**Submission on State Significant Infrastructure Proposal
North West Rail Link - Stations, Rail Infrastructure and Systems
(State Significant Infrastructure –SSI 5414)**

We have been appointed by BP Australia to review documentation relating to the above proposal, and examine the reasonableness of any implications of the proposal for the BP Bella Vista site.

Figure 6.27 Bella Vista Station - Indicative layout

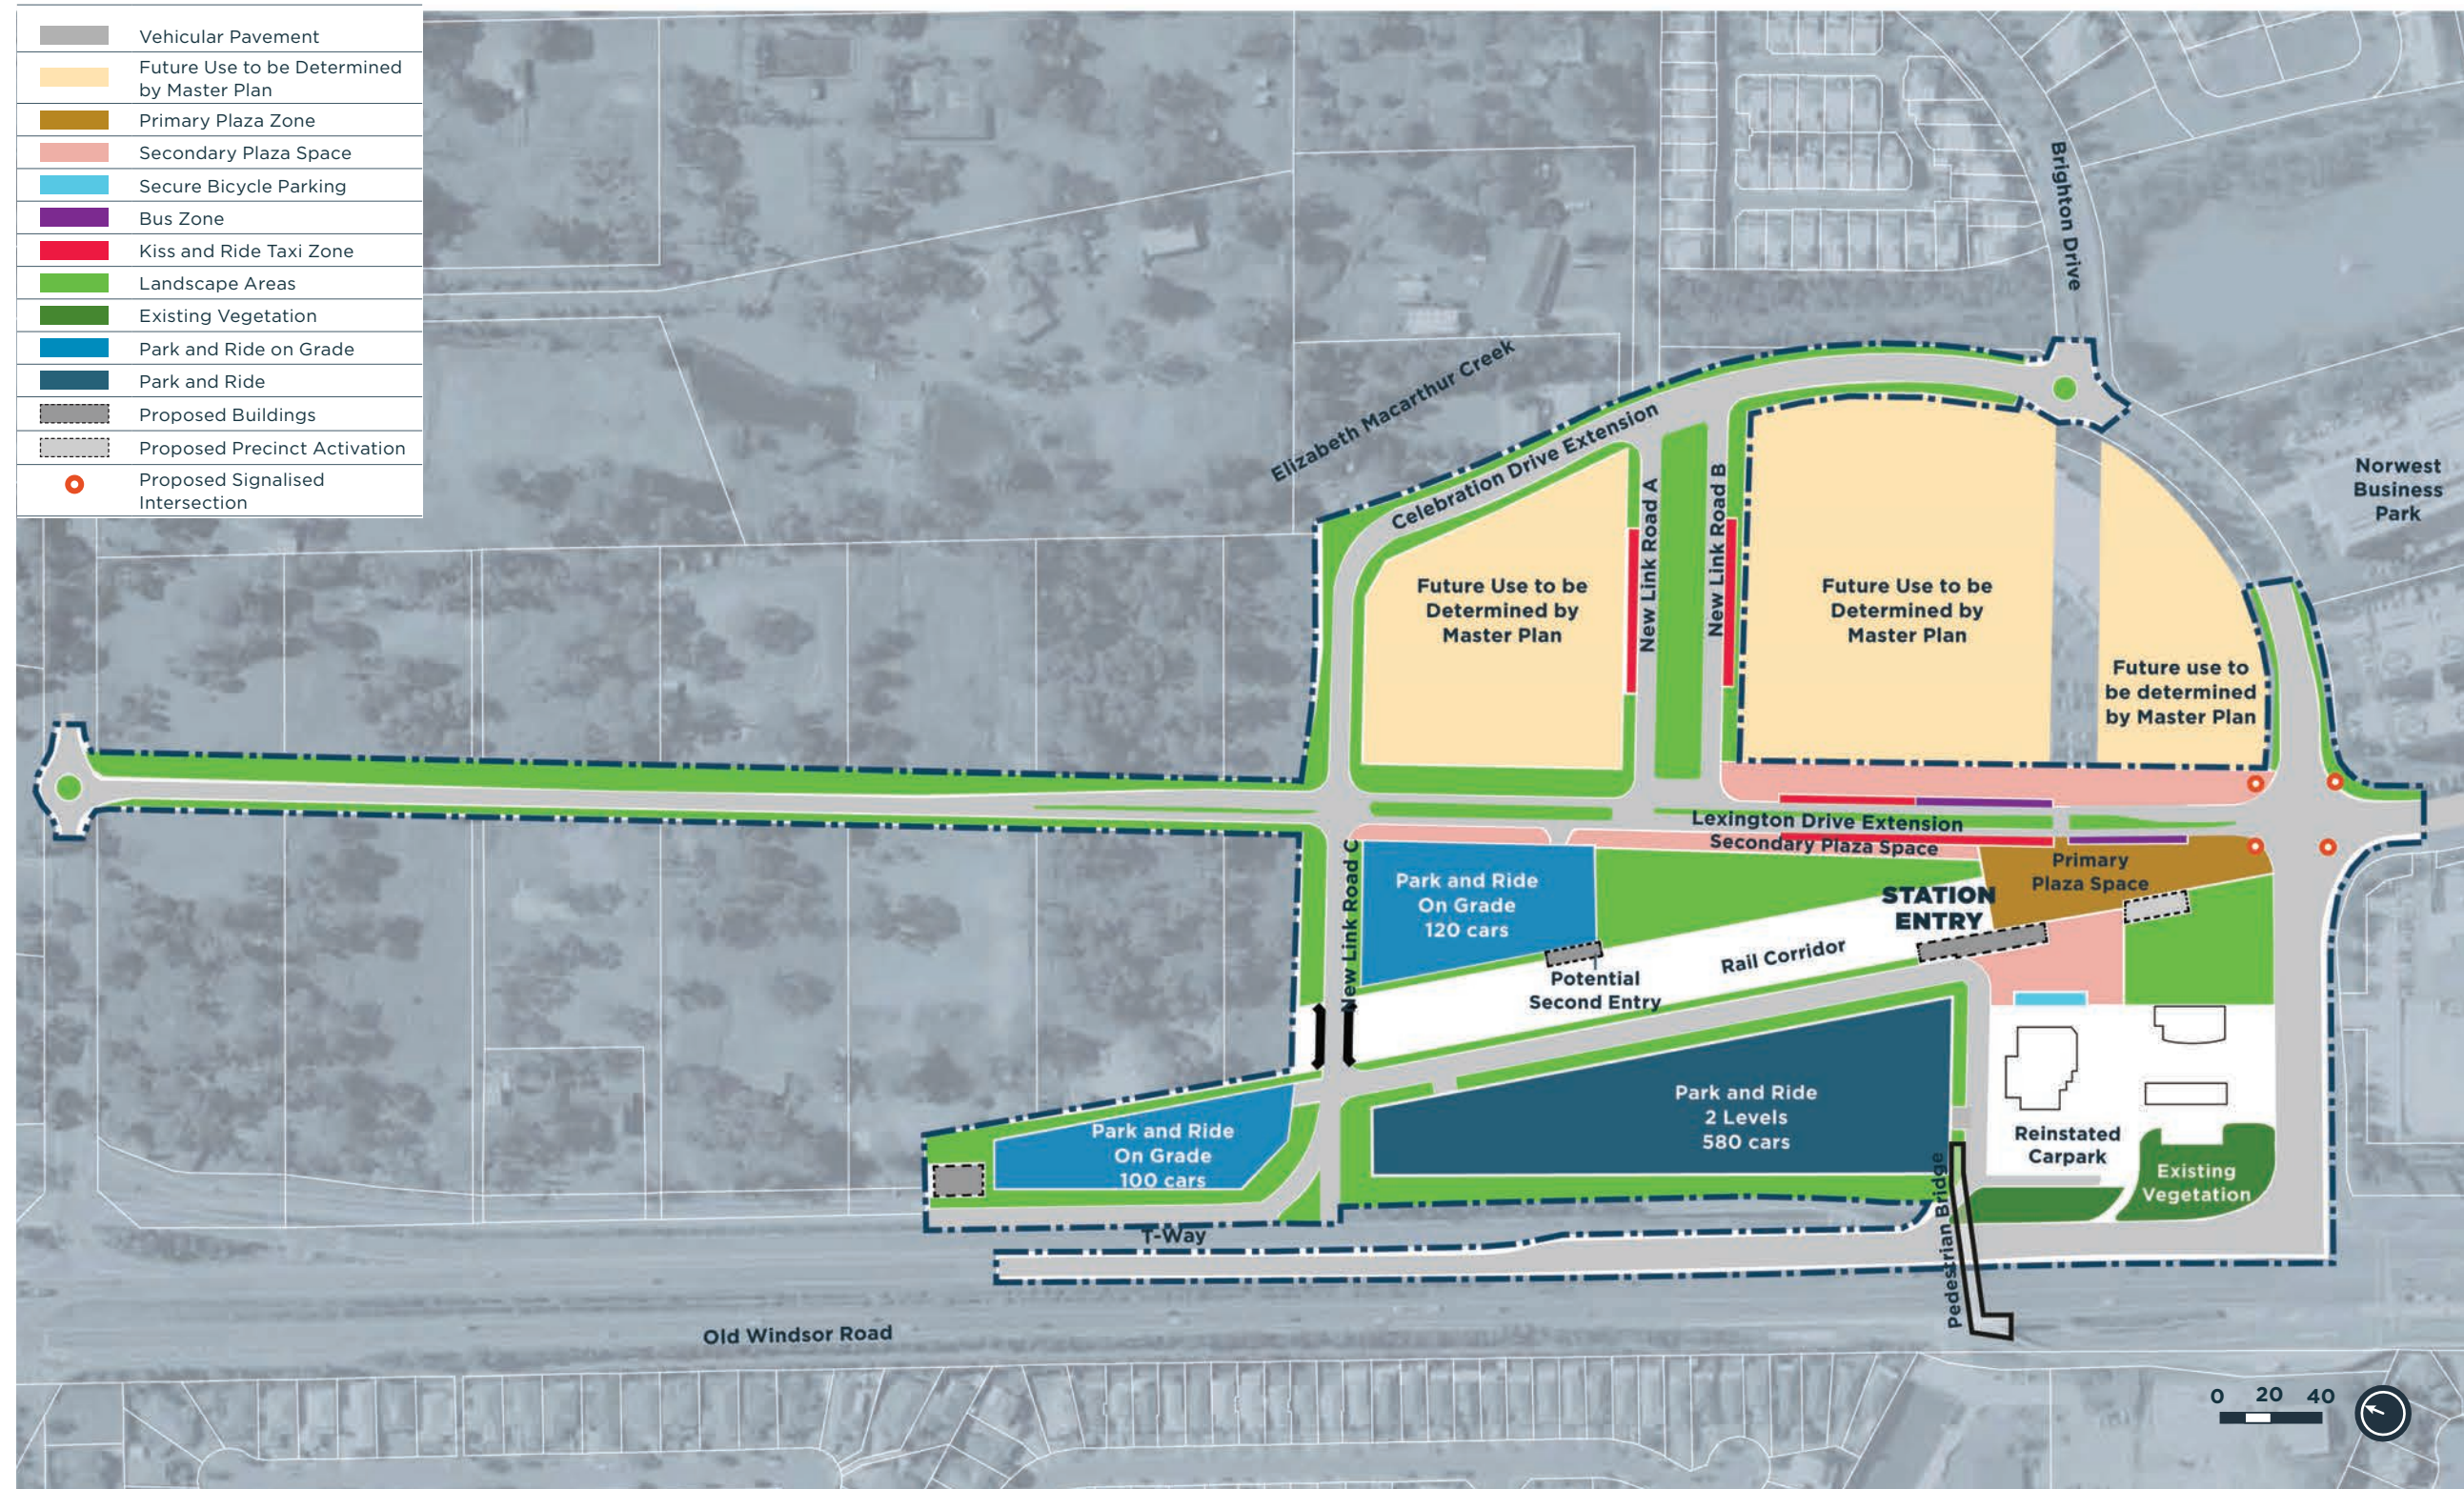
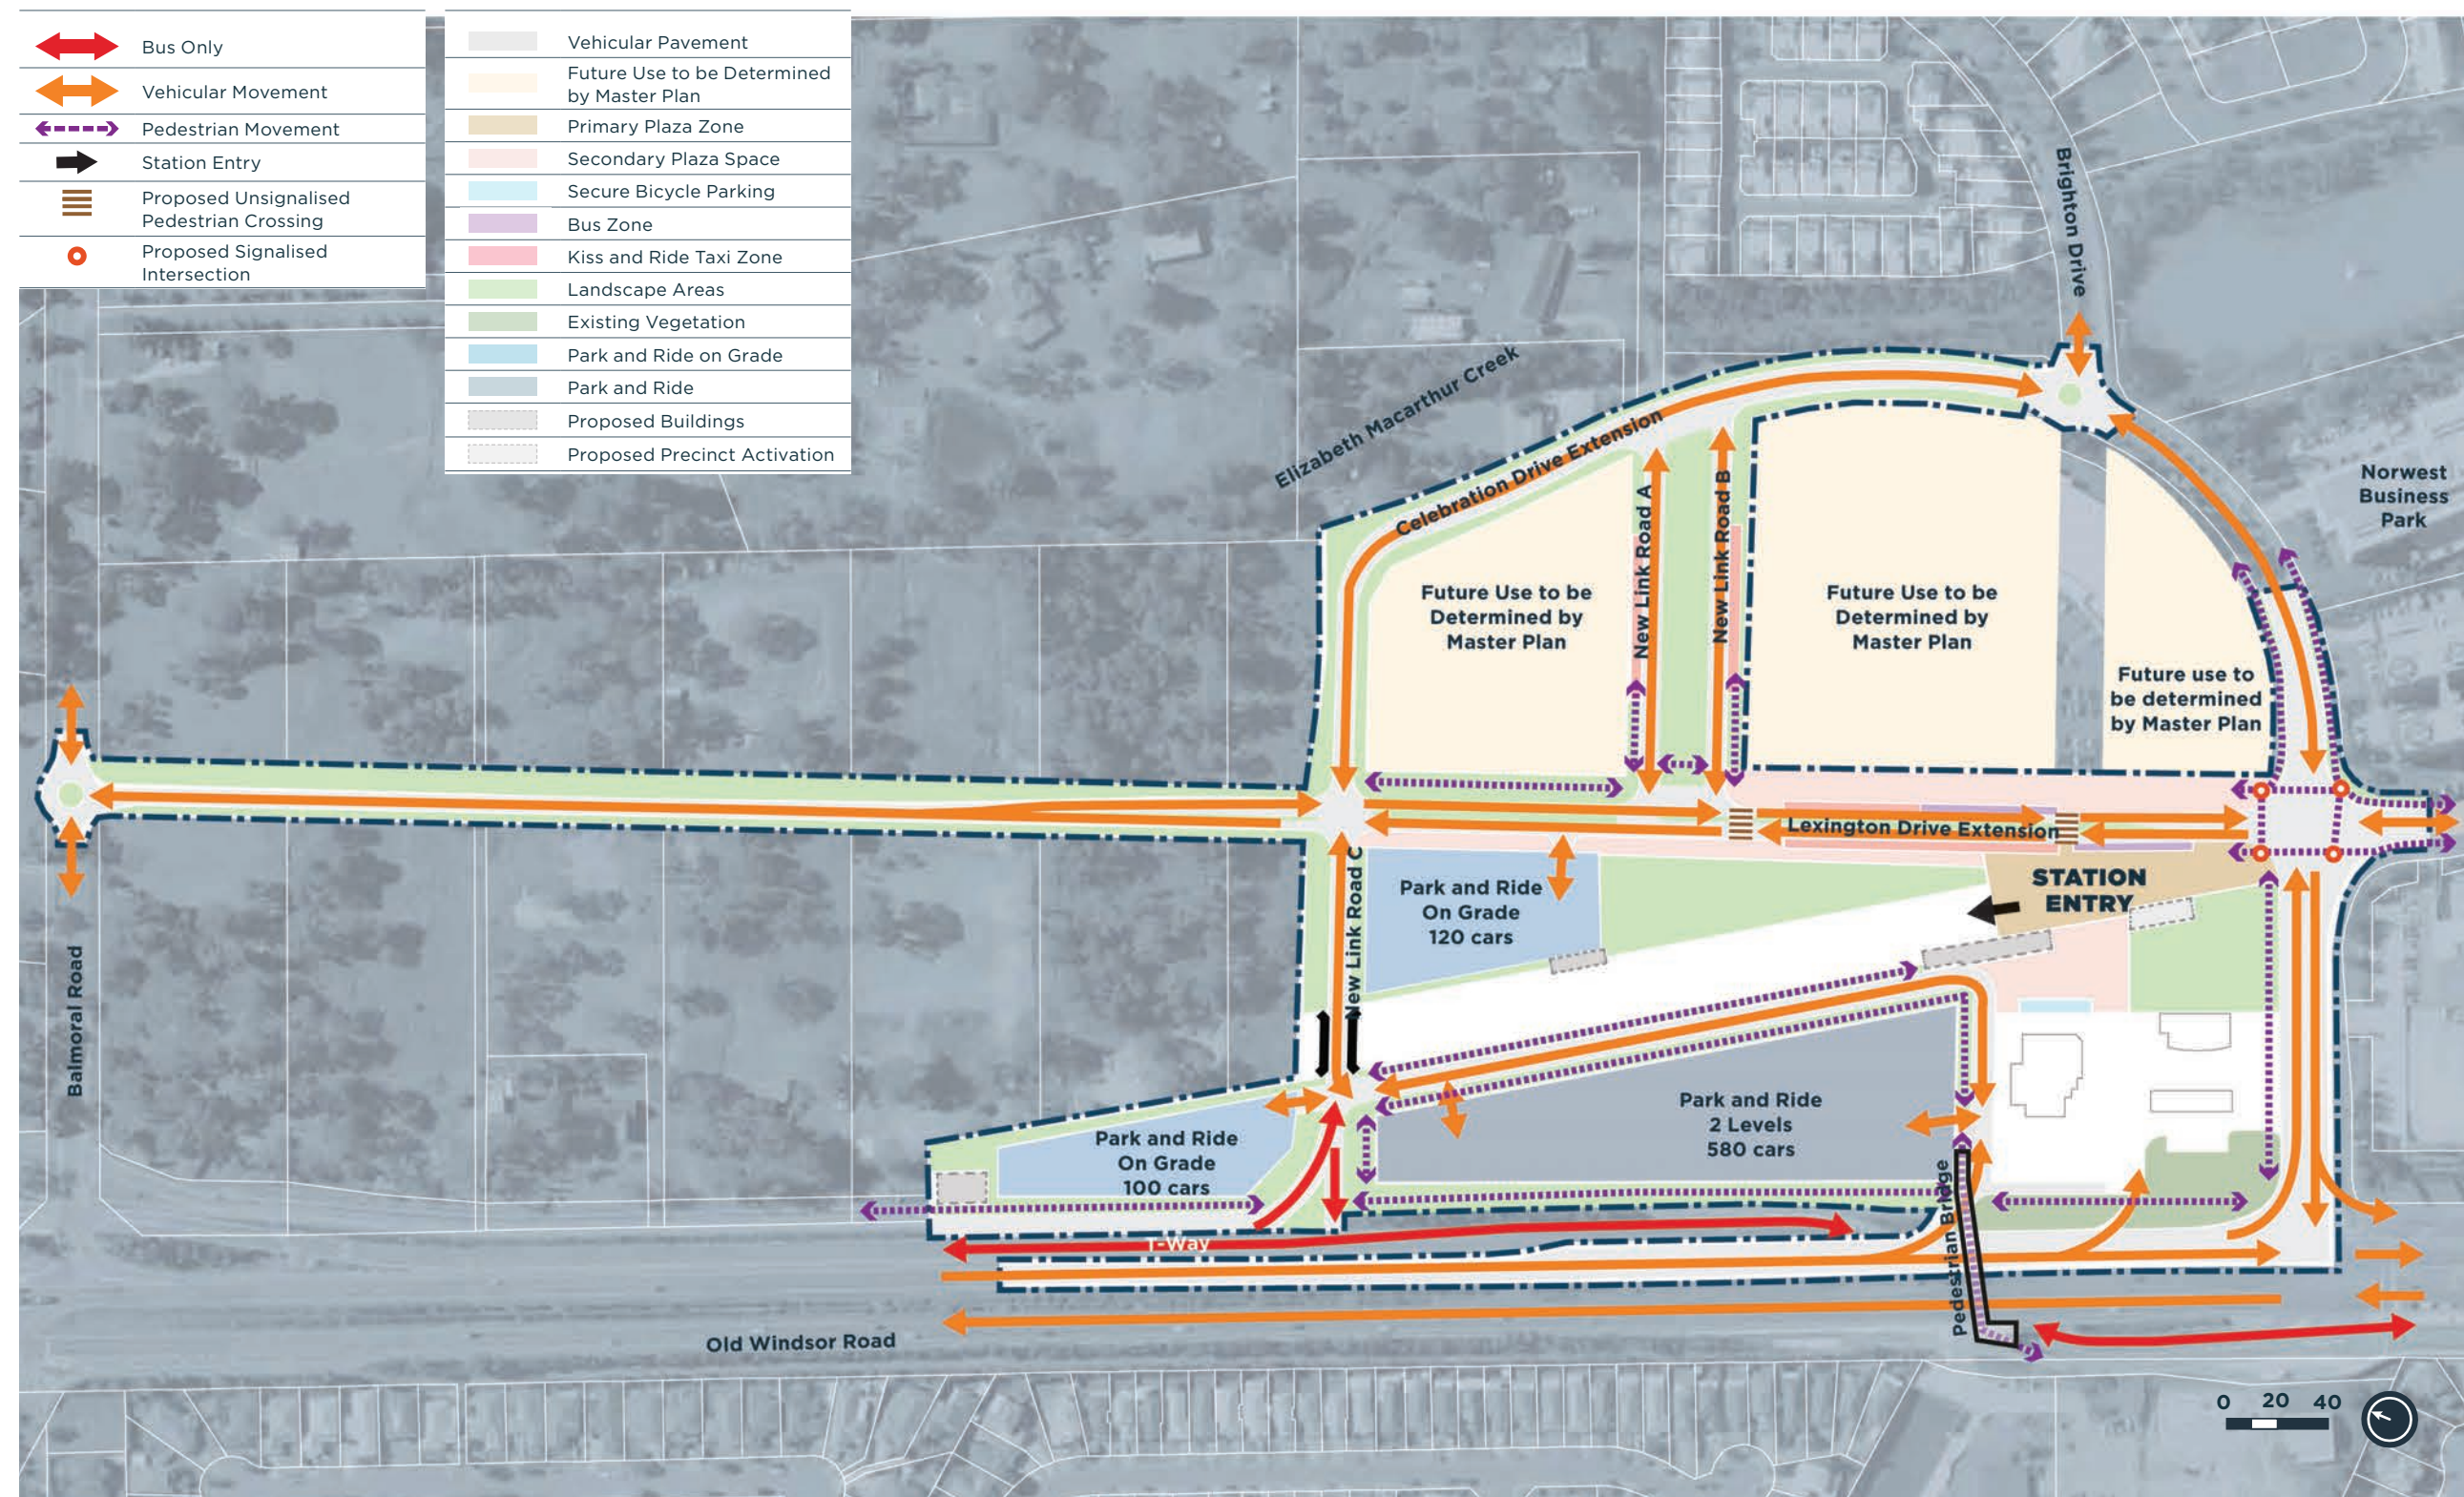
It is important that the environmental assessment for this project have a well-developed consideration of the effects of traffic changes associated with the project. It has been indicated by TNSW that the BP Bella Vista site impacts are a serious consideration in the work to date. However the technical reports accompanying the EIS do not seem to present a good understanding of the traffic context. Equally as importantly it seems that an undertaking to provide the “same level of access” (Source EIS p13-19) to the BP site when the project is complete has not been carried through in the current plan.

1. There is no recognition of the important traffic movement from the east and south-east to the BP Bella Vista site. At present the BP Bella Vista site garners significant trade from the commercial and residential land uses east and south-east. This occurs in particular during the PM peak (and BP notes that refuelling is more common at PM “on the way home” than AM peaks). As presently conceived, the removal of the roundabout at the Celebration Drive/ Lexington Drive intersection denies entrance of traffic from the east and south-east via the current extension to Lexington Drive and Homemaker

Centre. This traffic movement is ignored in EIS2 Technical Paper 2-1 (Section 8.5.4) when it considers the impact of the removal of the existing roundabout.

2. Continuing on from the above, there is no evidence of appreciation of the idiosyncratic attraction factors for the BP Bella Vista service station site¹. It needs to be recognised that convenience is the key point of attraction for service station users. In turn the directness of the egress movement is equally as important as that of the ingress movement beyond one-off trade. At present a large volume of users enter the site with the intent of egressing back to Old Windsor Road via the convenient and traffic light free movement of the Celebration Drive/ Lexington Drive roundabout. The loss of this roundabout completely changes the attractiveness of the site to a large portion of visitors. The suggestion of alternatives at EIS2 Technical Paper 2-1 (Section 8.5.4) which variously involve longer routes or movement through a number of traffic signals may be attractive to “destination” traffic but removes the “convenience” which is essential to the current service station attraction.

3. Suggested “New entry to the McDonalds outlet via Celebration Drive” at Section 8.5.4 needs further explanation. This new entry seems to be indicated in one of the drawings (Figure 39 very difficult to read) but not the main EIS documents, or in a document kindly provided to us by email from TNSW on 27/11/2012. There is a good opportunity for continuing integration of the BP Bella Vista site and McDonalds and this should be encouraged.

BP is likely to be very directly impacted by this project. It is hoped that “the same level of access” can be obtained to the BP site in the current masterplan for the precinct (eg via an accessway from the north of the BP site to Lexington Drive north) or unresolved planning considerations can be accommodated in future modification applications if necessary. However, it would be entirely inappropriate if the Department of Planning’s assessment (and Minister’s determination) of this proposal was based on an understanding that “the same level of access” can be obtained to the BP site when traffic management plans prepared sometime in the future do not provide such a standard of access.

The proponents have not yet indicated how they intend to deliver on the undertaking to provide the “same level of access”. It is recommended that this occur through the preparation of a Traffic Management Plan for
